**Planning Department  
Transportation Development Services**

July 11, 2014

**Re: Wendy's, 3601 4<sup>th</sup> St NW**  
**Traffic Circulation Layout**  
Architect's Stamp dated 6-26-14 (G14-D031)

REMODEL/ADDITION SITE PLAN

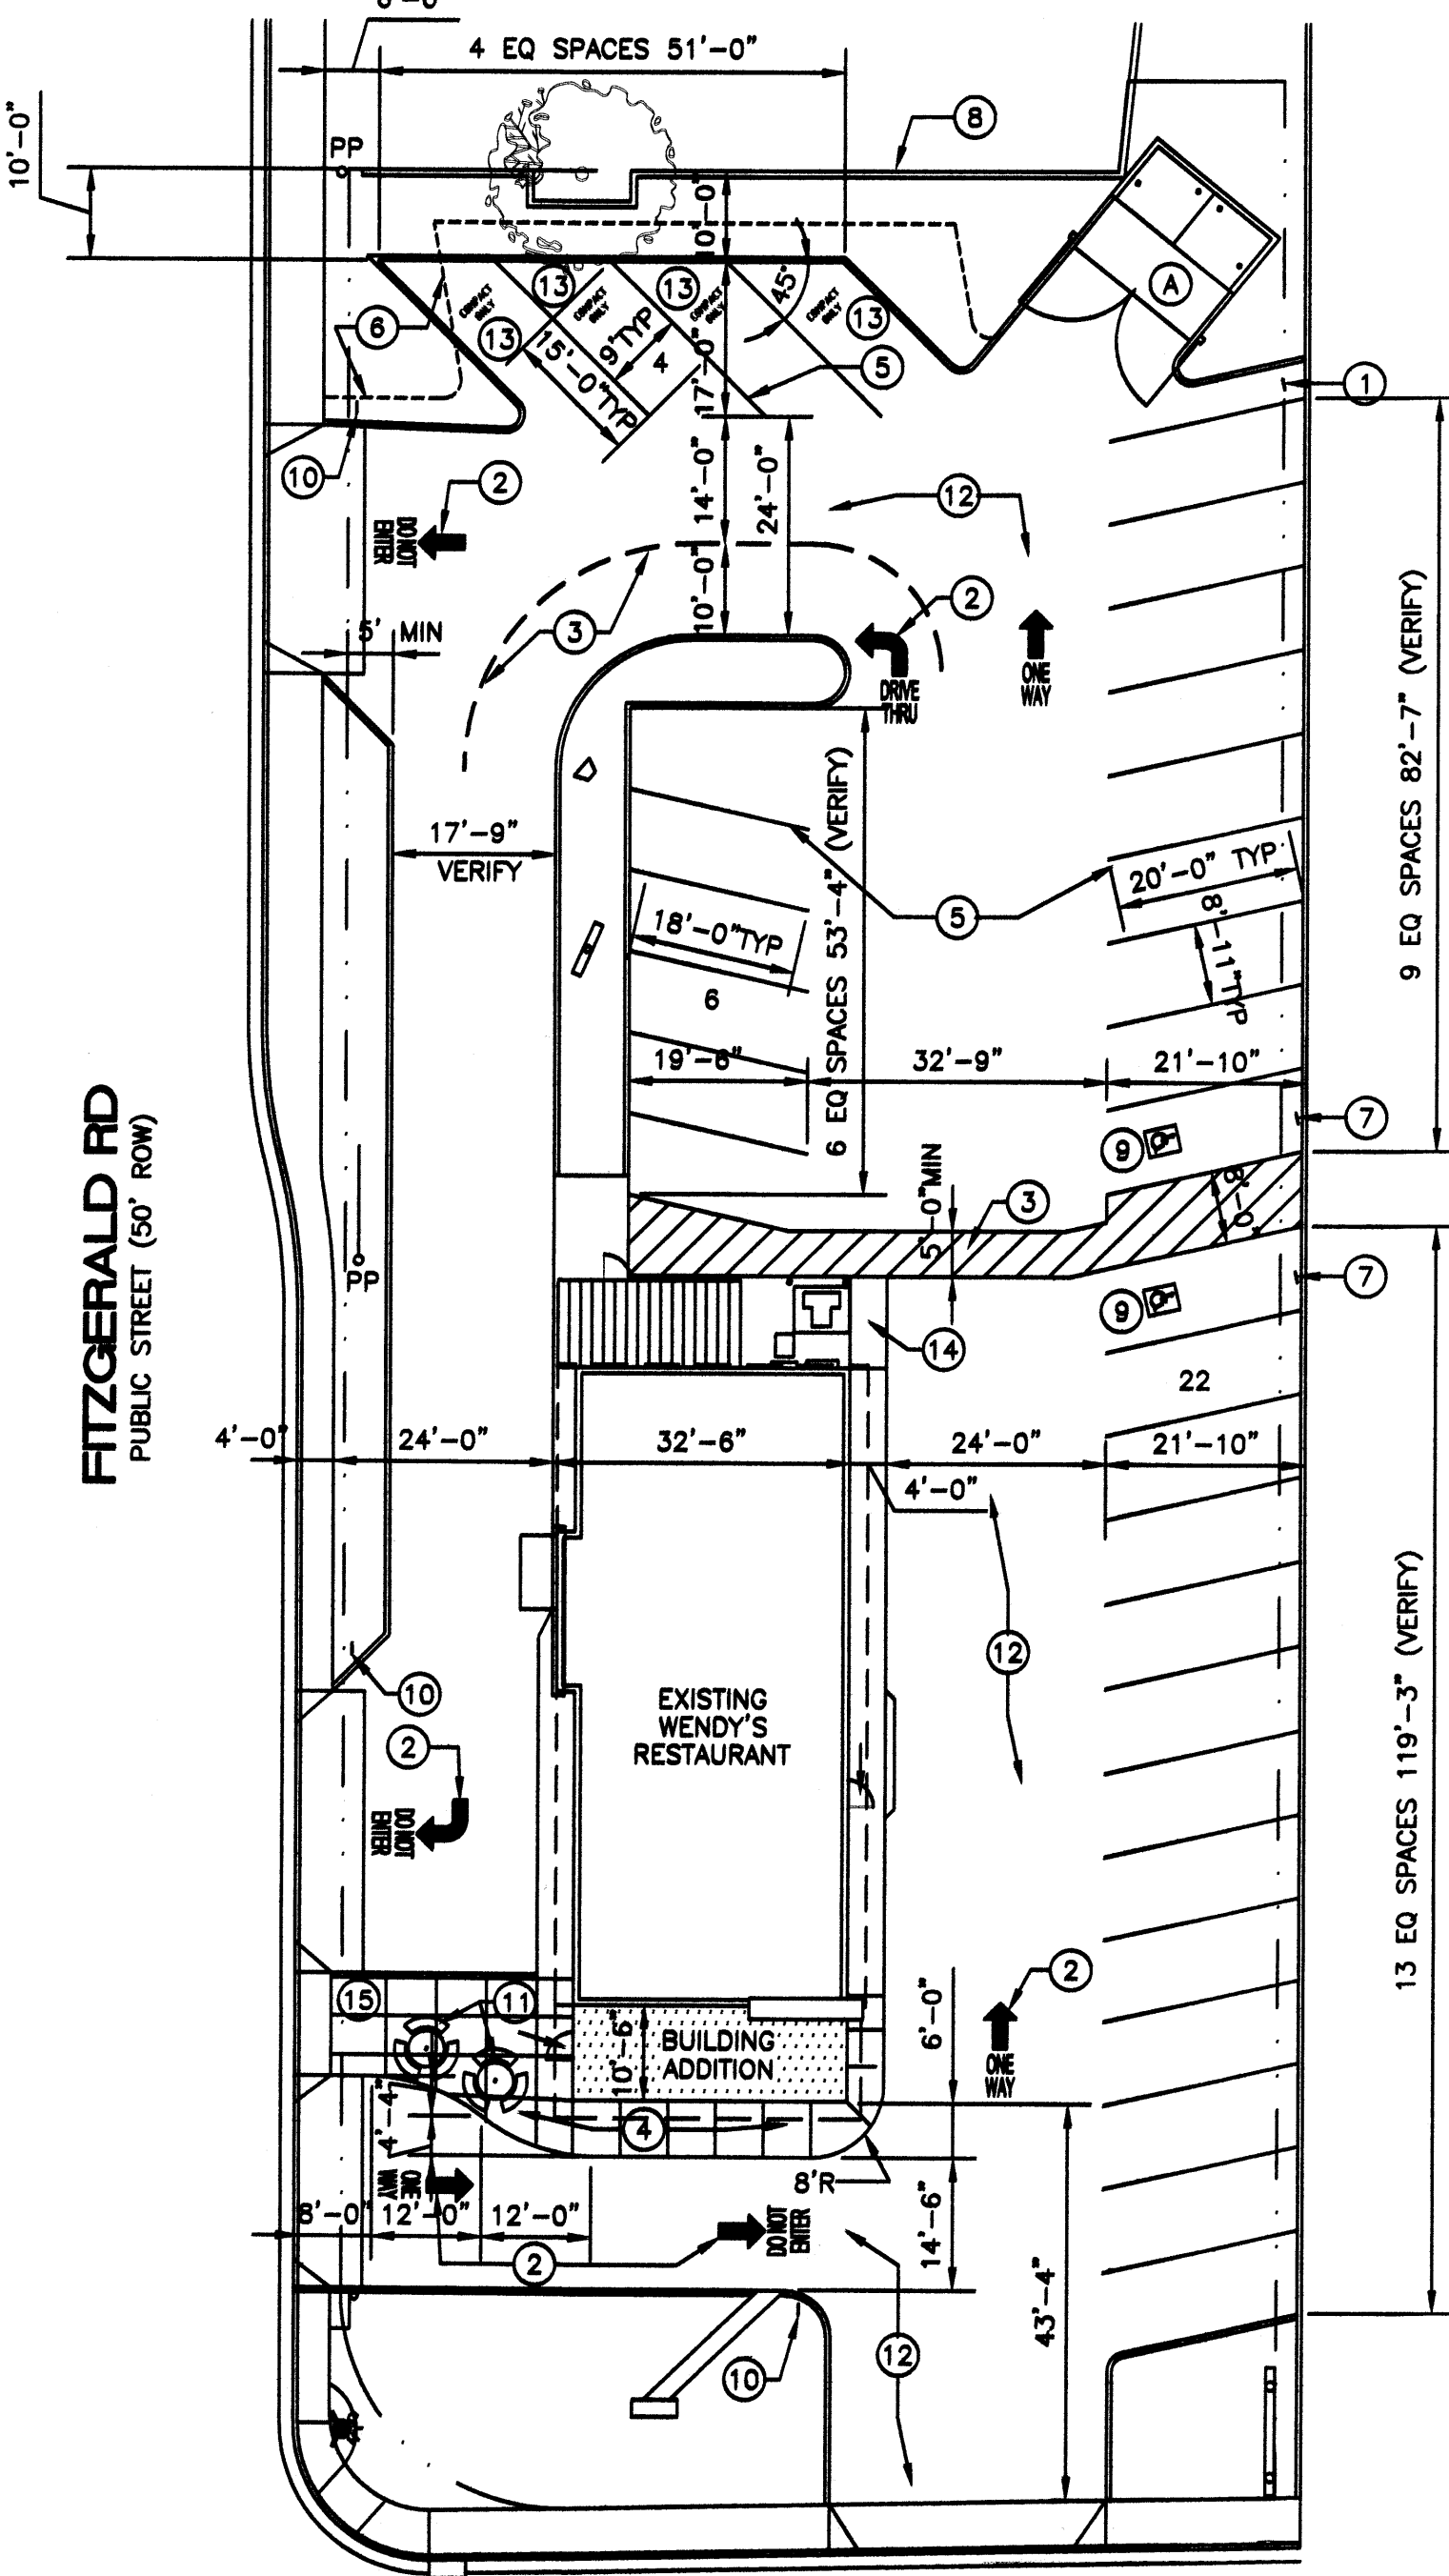
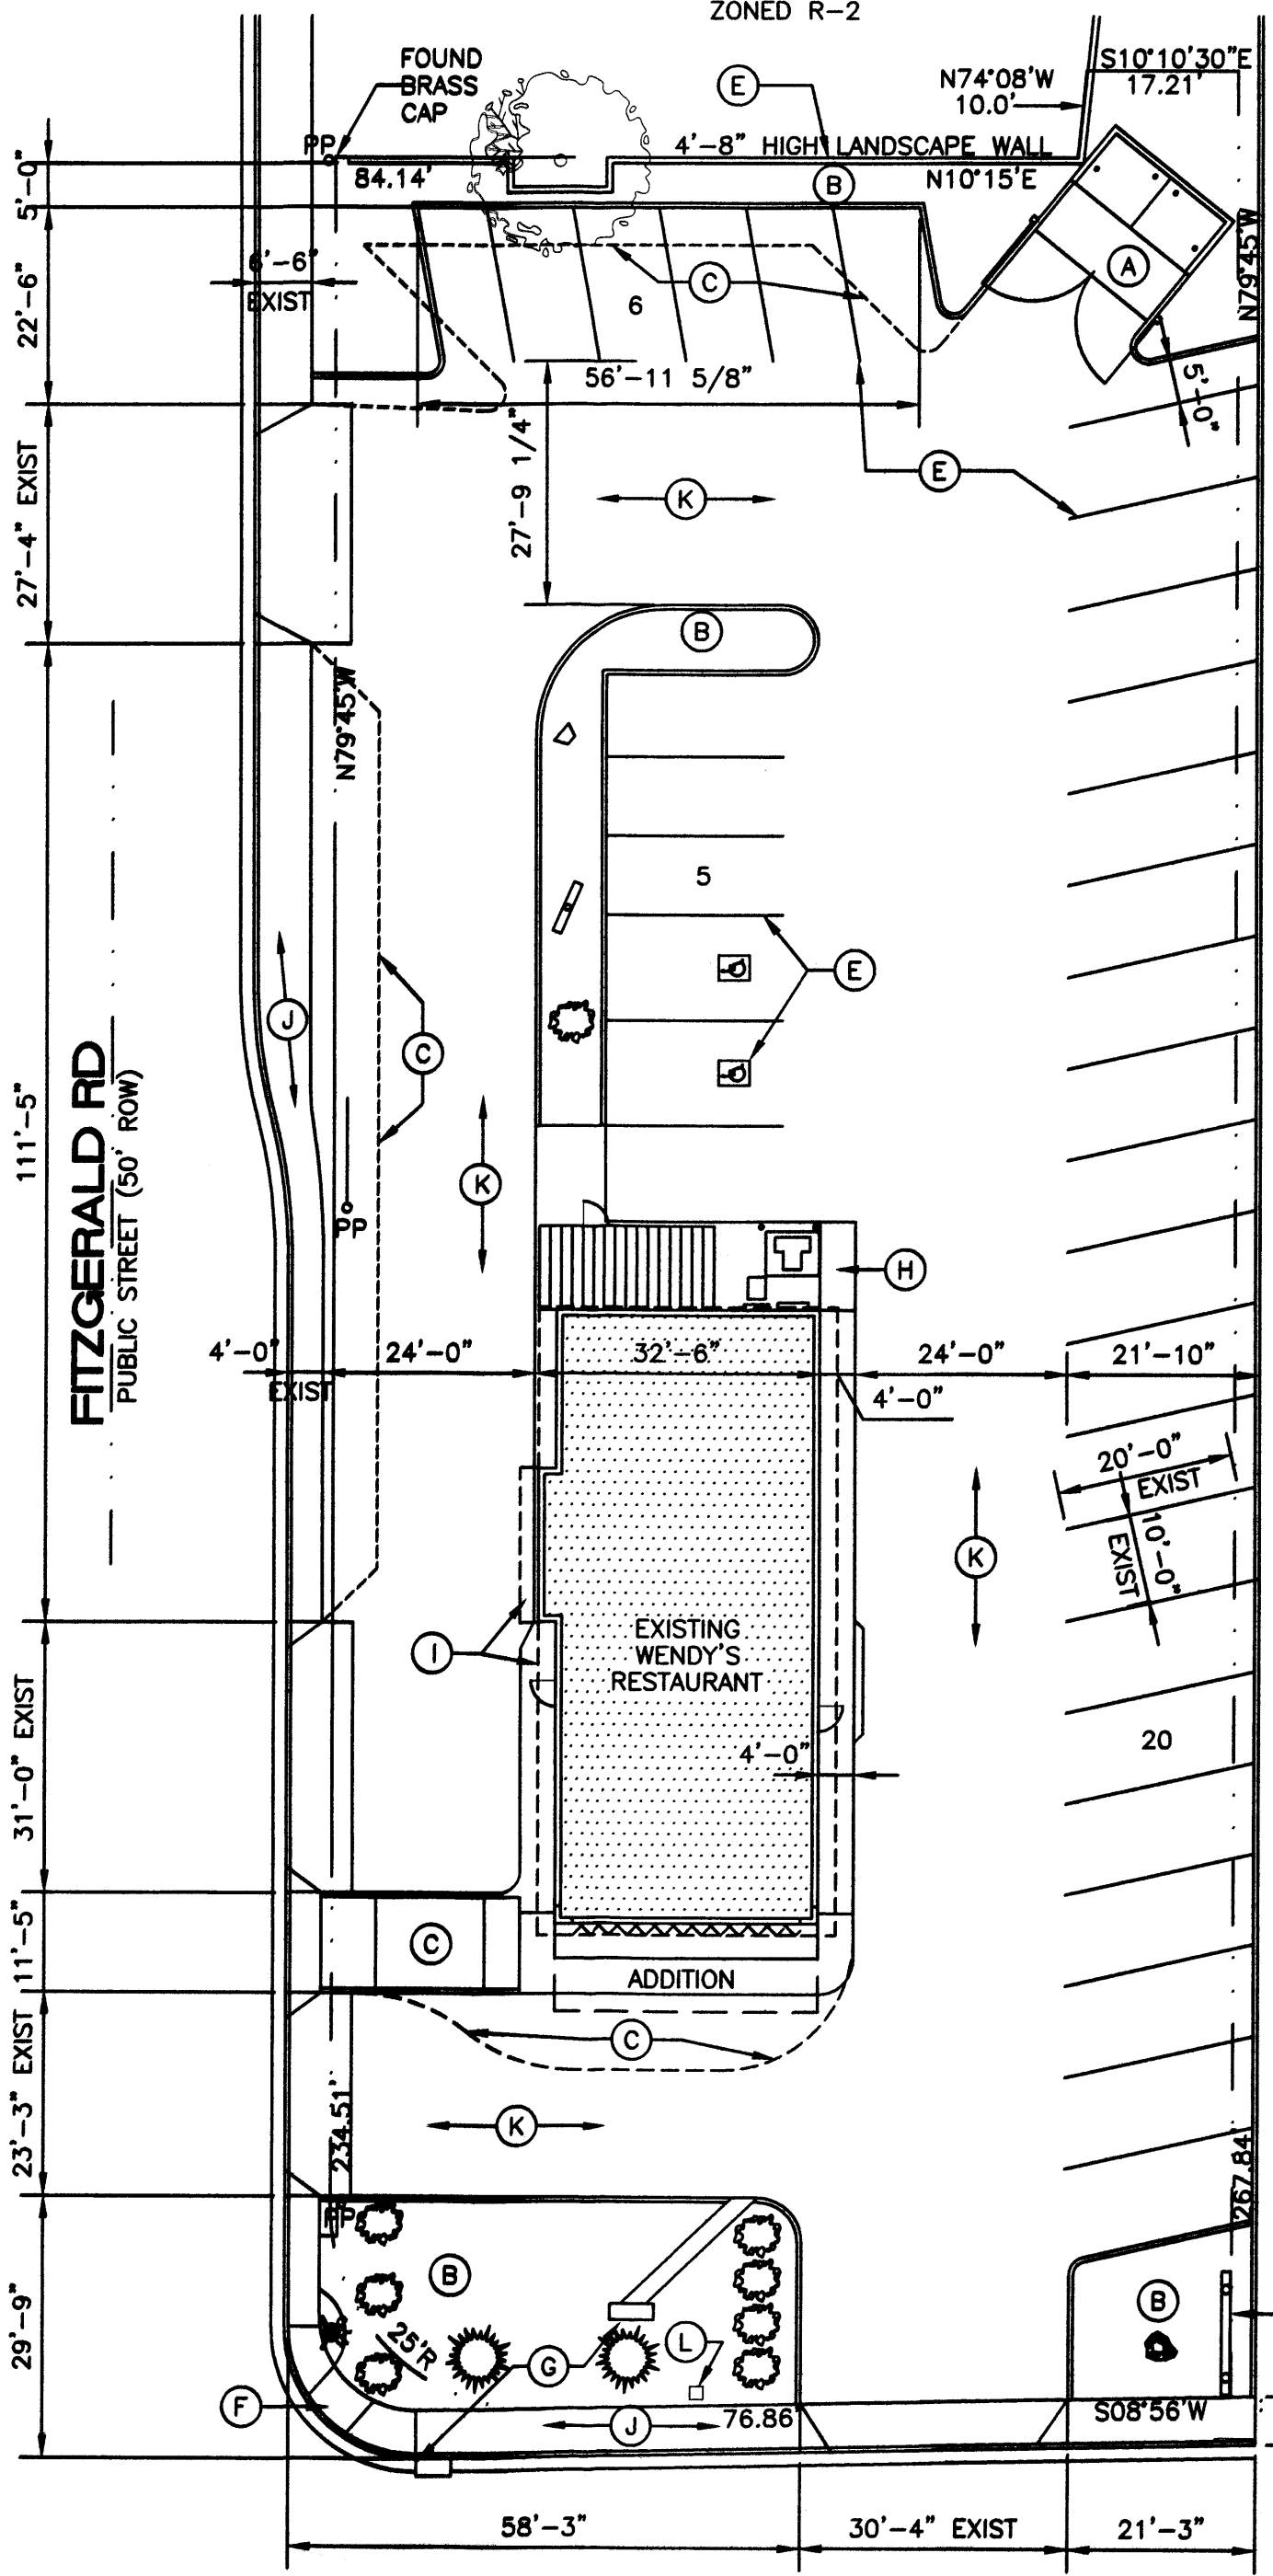
1. Please list the width and length for all parking spaces.
2. Please show a vicinity map.
3. The handicap accessible spaces must be a minimum of 8.5 feet in width.

4. The handicap accessible spaces must include an 8-foot wide van access aisle; all other aisles should be 5 feet in width.
5. Please provide a detail of the handicap accessible parking signage

6. Provide a heavy vehicle pathway on the plan.
7. Please include two copies of the traffic circulation layout at the next submittal.
8. Show the pedestrian pathway and ADA access to the building including all ramps.

9. How will ADA access be taken to the entrance of the building? The door appears to swing in the path way.
10. Please provide an easement for any sidewalk within the right-of-way.

11. Please provide approvable signage and striping i.e. one-way and do not enter.
12. Please remove non applicable note "7" from the TCL plan.
13. We suggest that the parking on the west end of the property be changed to compact parking to widen the drive aisle.
